**RE: *Green Mountain Falls County Documents Review Comments and Redlines***

OVERALL SITE PLAN
SHEET 2 OF 14

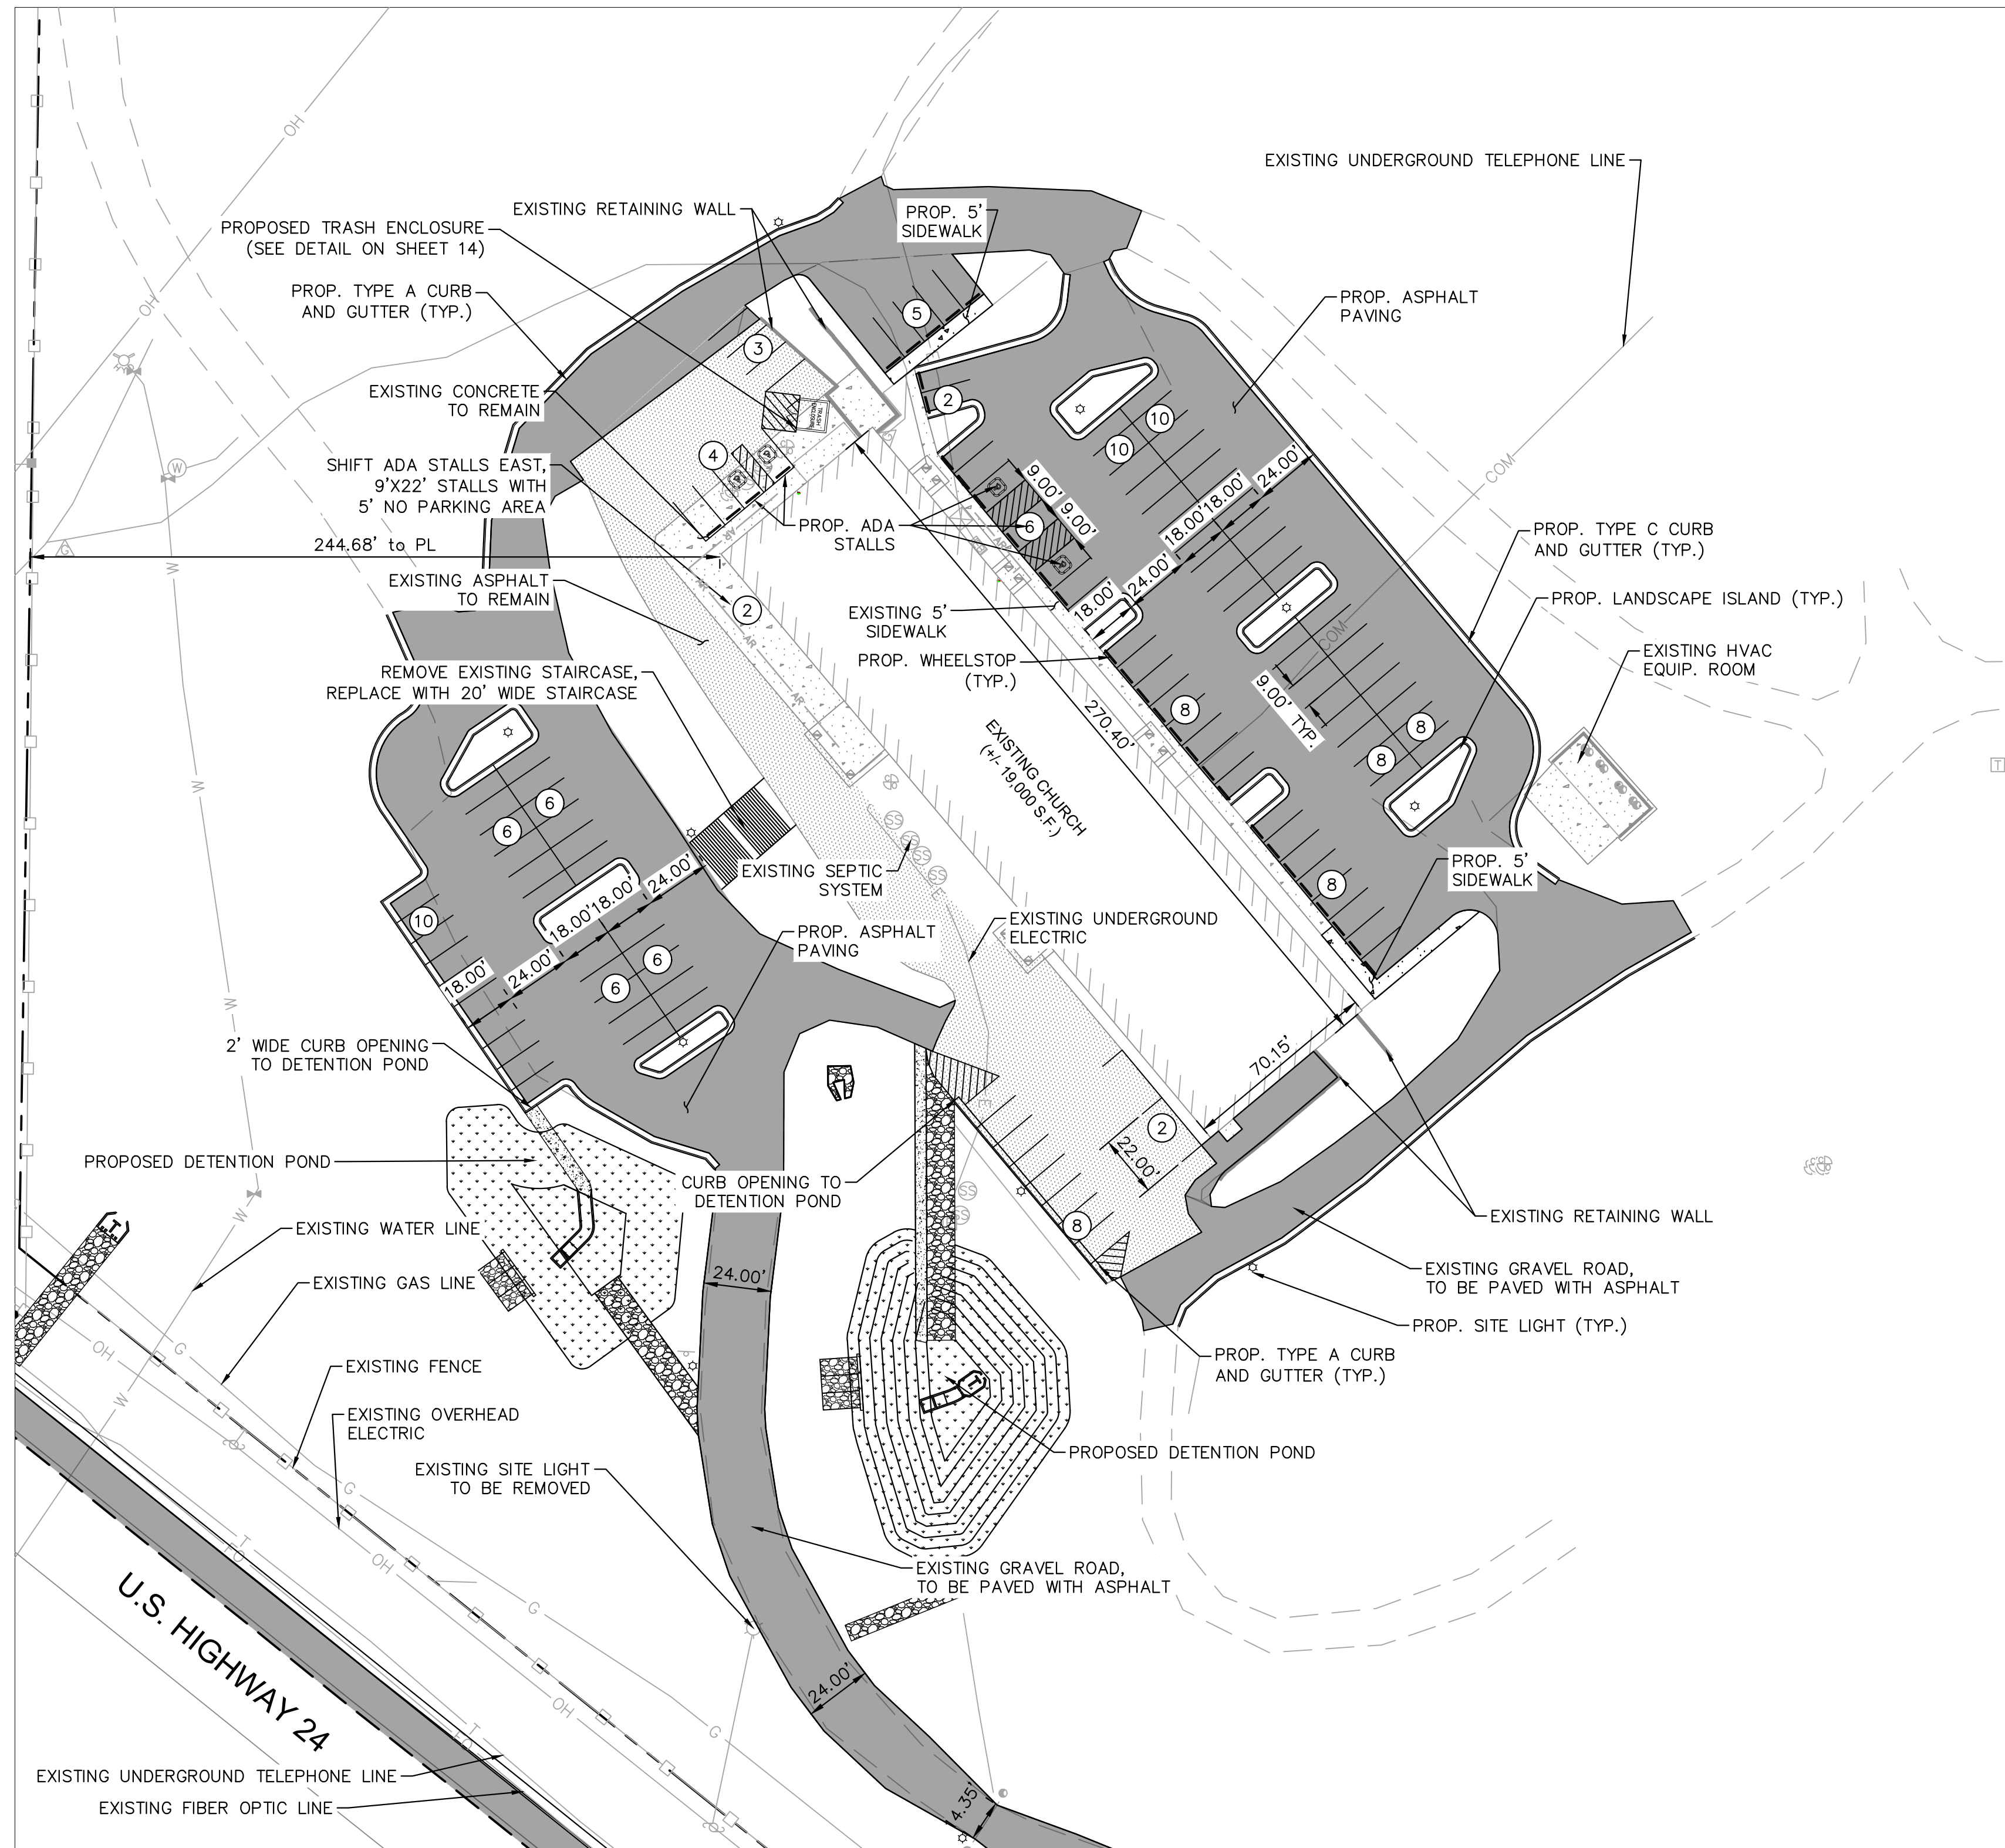
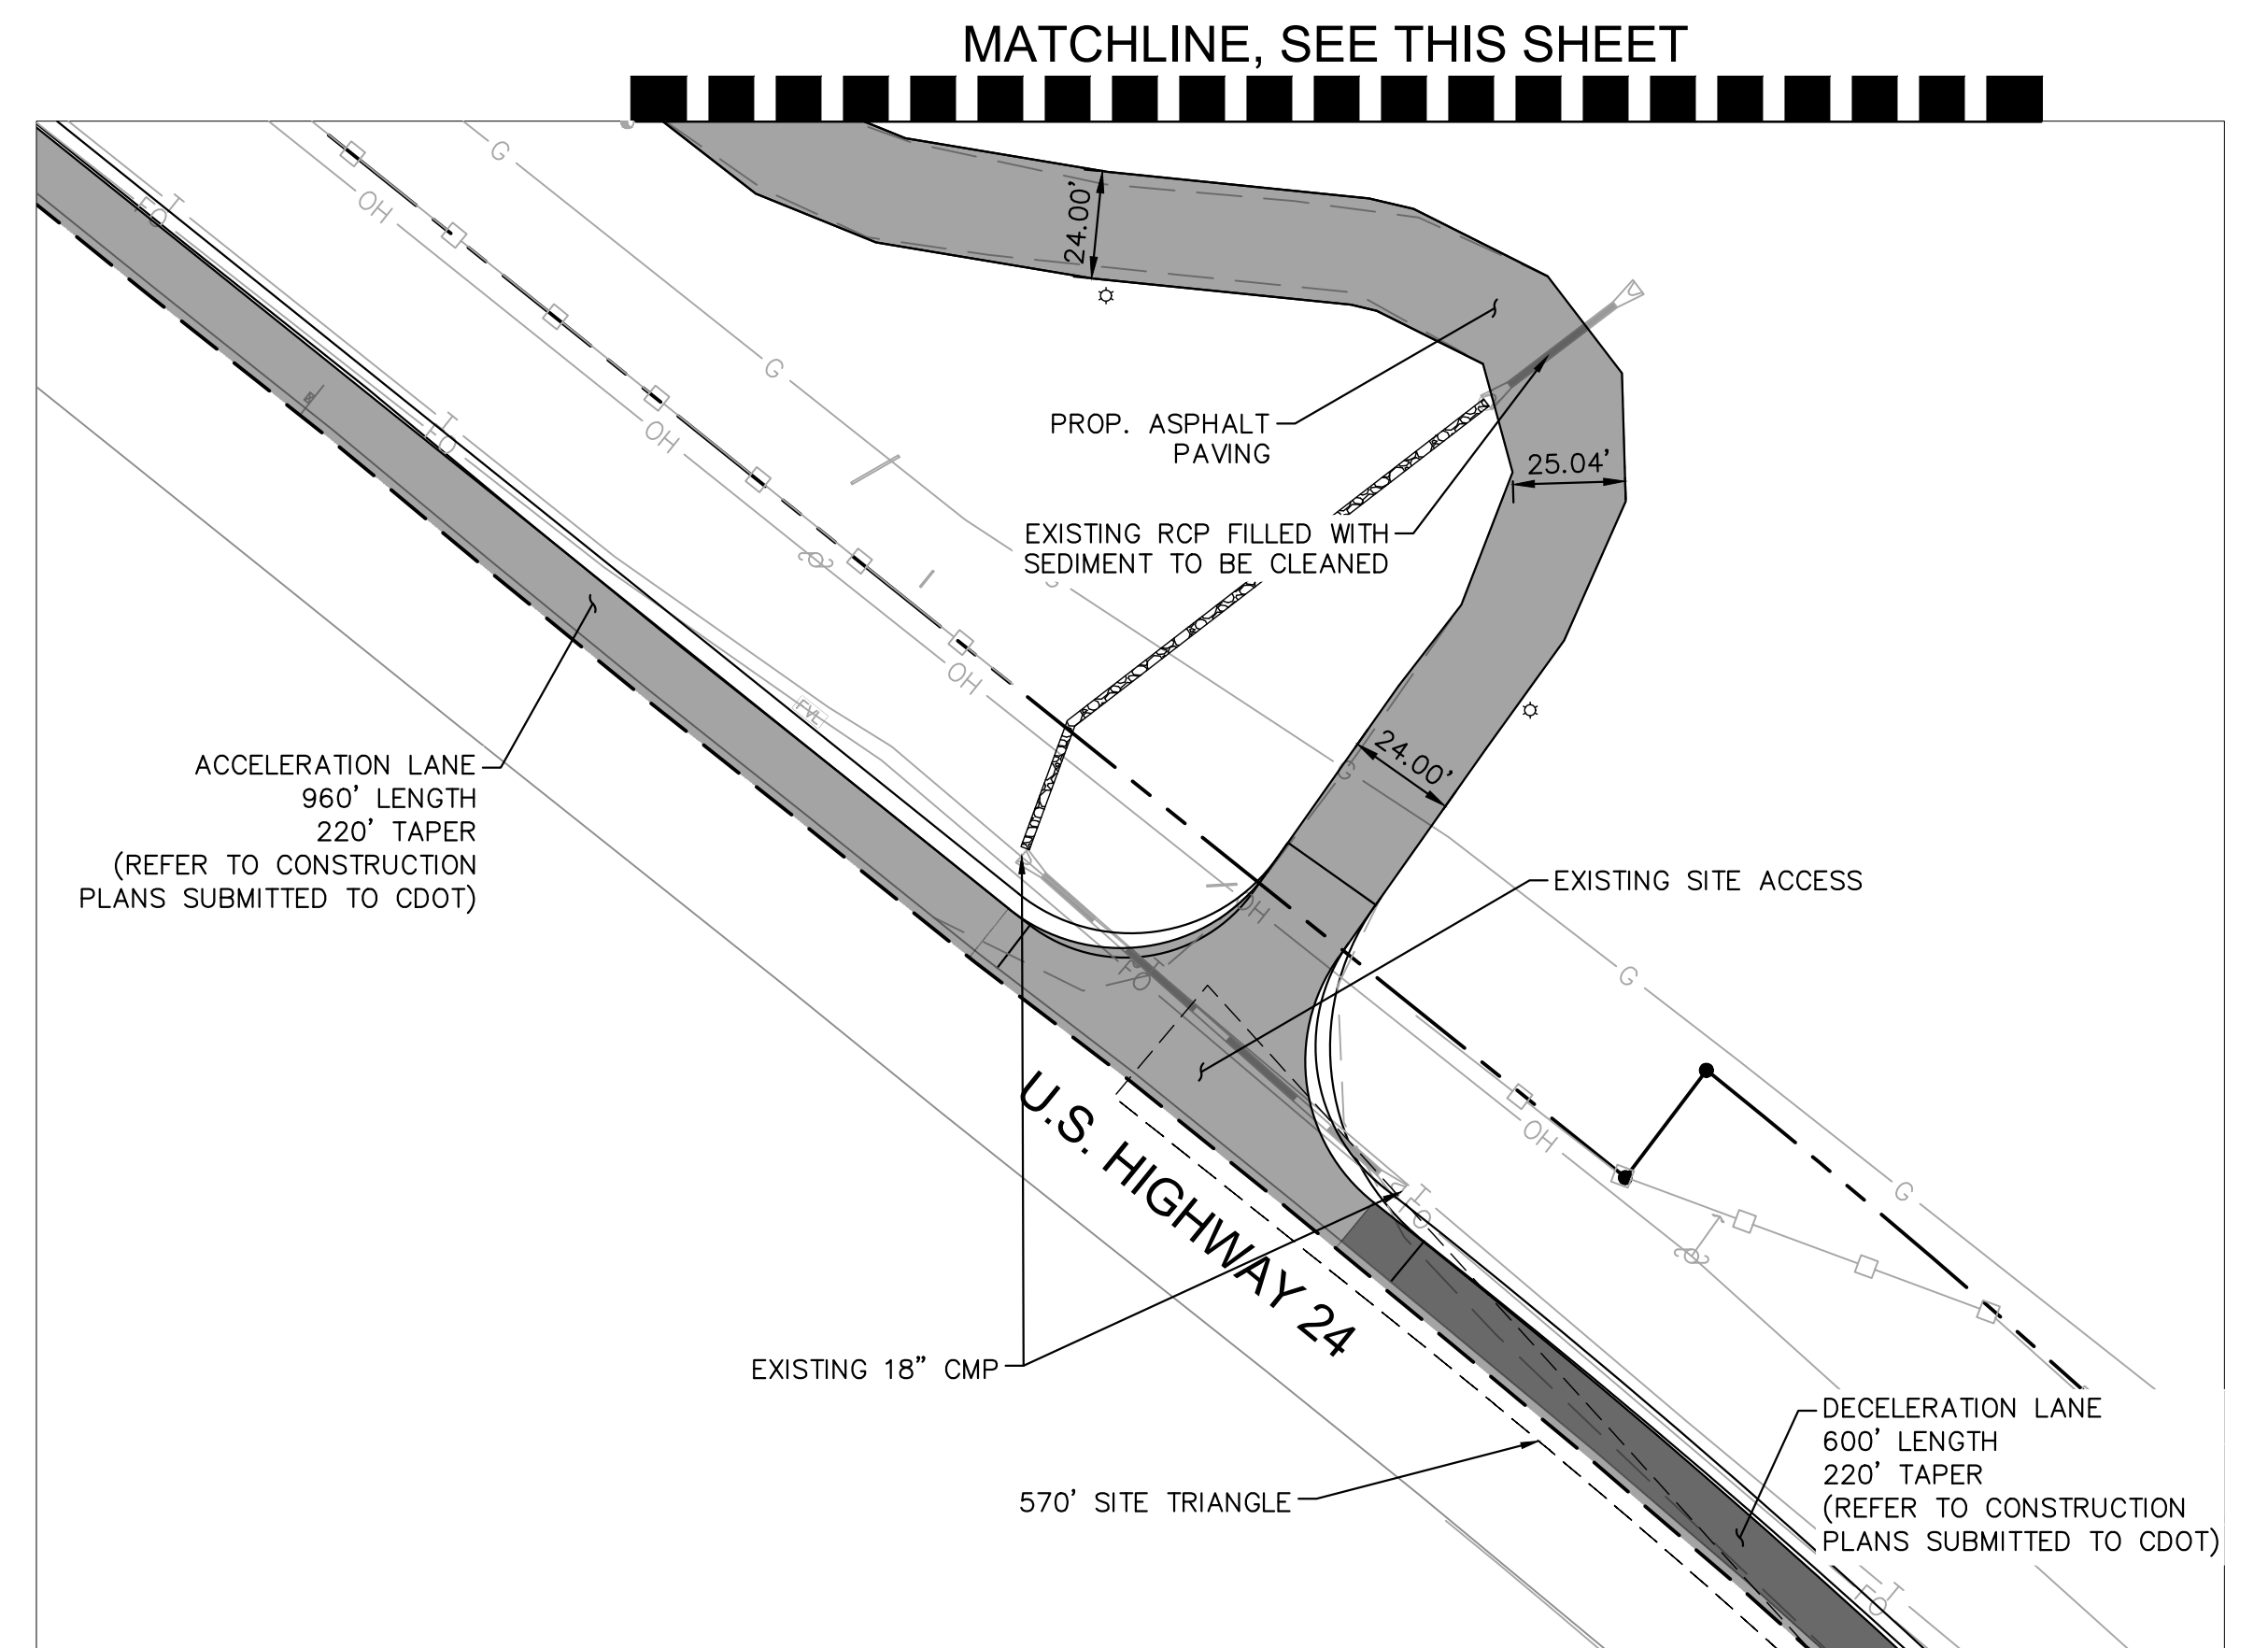
2. Parking information does not match which is shown on the previous page. Revise accordingly.

3. Unresolved. The building capacity also does not match the previous page. Please revise so that all the information is matching.

*Response: Confirmed to be 423 seats.*

*Response: Confirmed to be 423 seats.*

3 EXISTING EAST FACADE (NO WORK BEING DONE)
SCALE: 1/8" = 1'

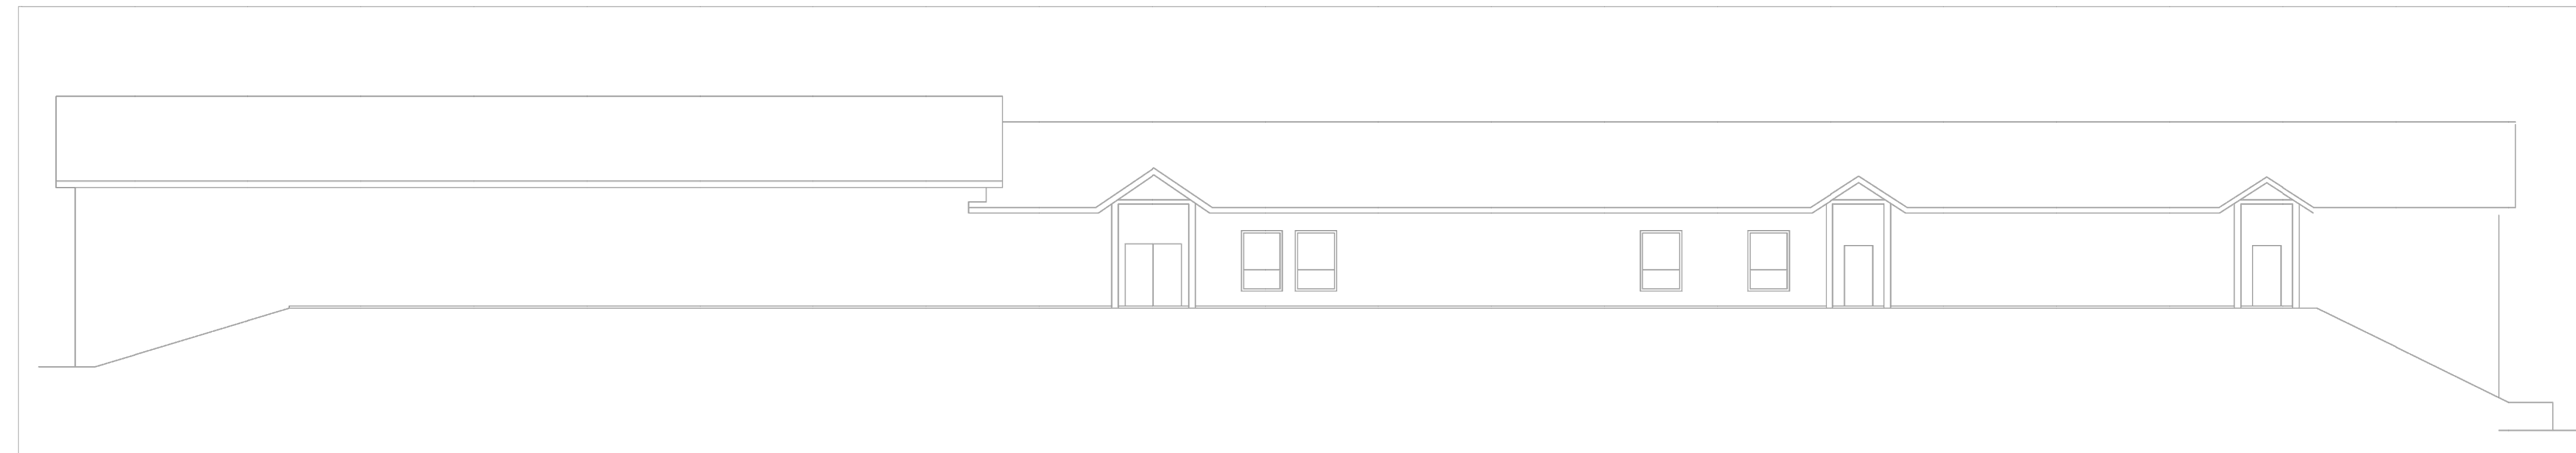
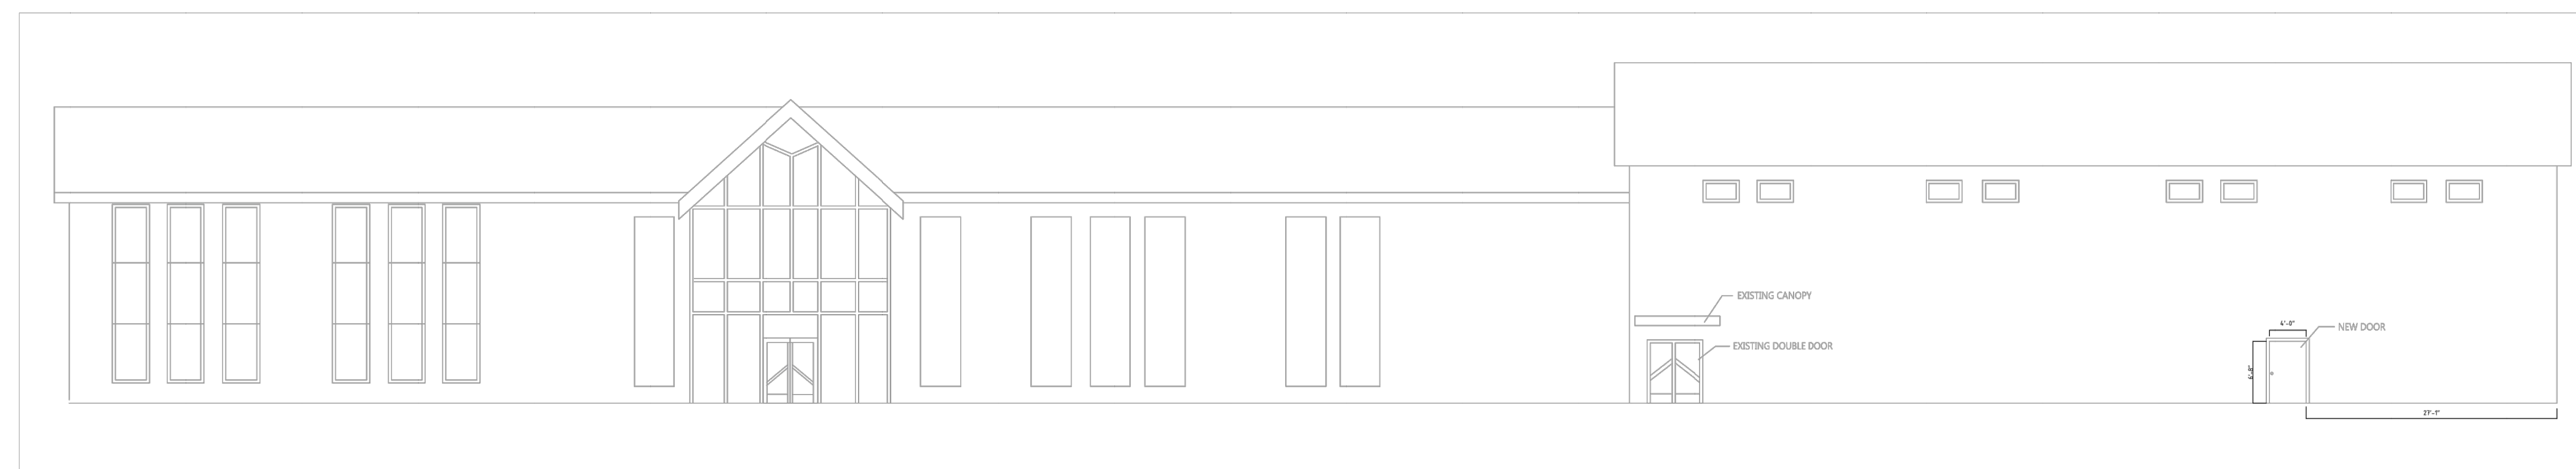
3. It is understood that only the front façade will undergo renovation. Please provide a sheet with photos showing the existing conditions of the other facades for reference.  
*Response: These photos have been provided alongside the building elevations.*
